Our Ref: FP/259/19/HH
Your Ref:

Town & Country Planning Act 1990 (as amended)
Town & Country Planning (Development Management Procedure) (England) Order 2015
Application for Planning Permission for Works or Extension to a Dwelling

Development Proposed new dormer, new front entrance porch and alterations
Location 5 Normans Drive Felpham

Proposed Rear Elevation (West)

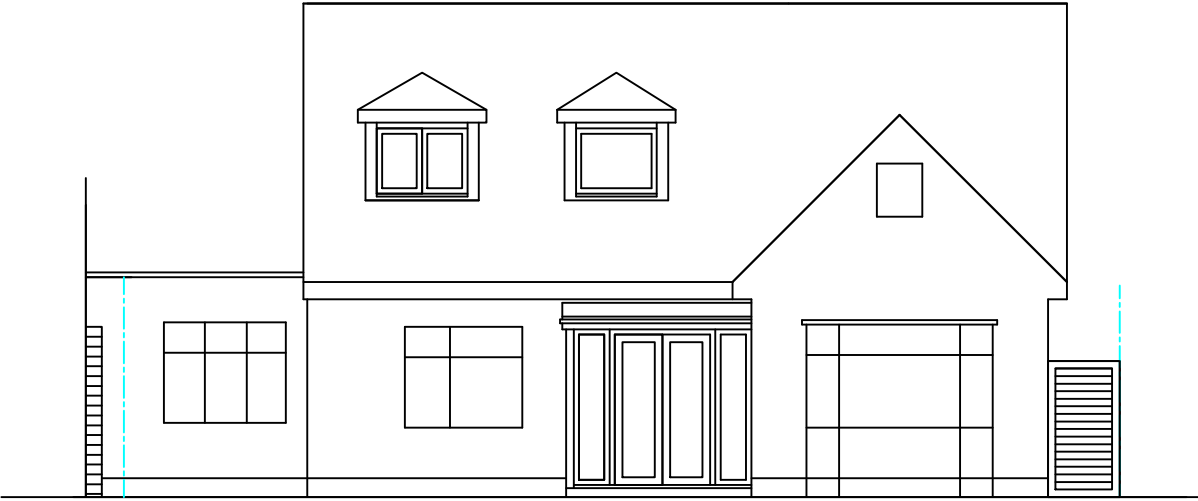
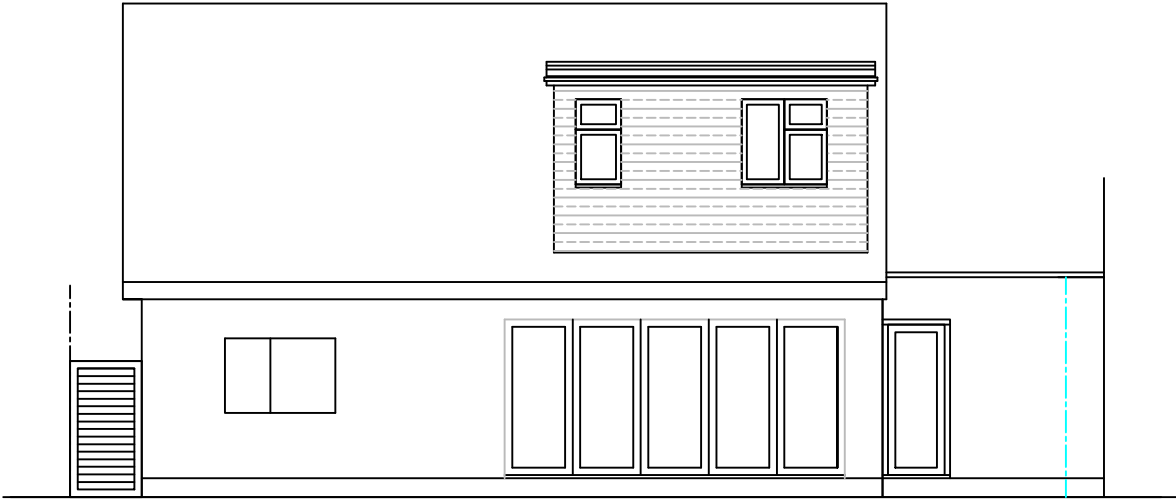
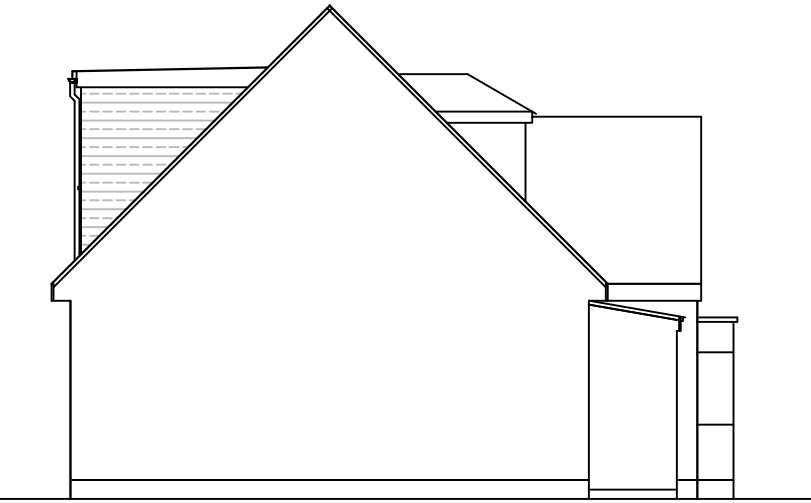
Labels: The proposed rear elevation has been labelled existing elevation. Please amend.
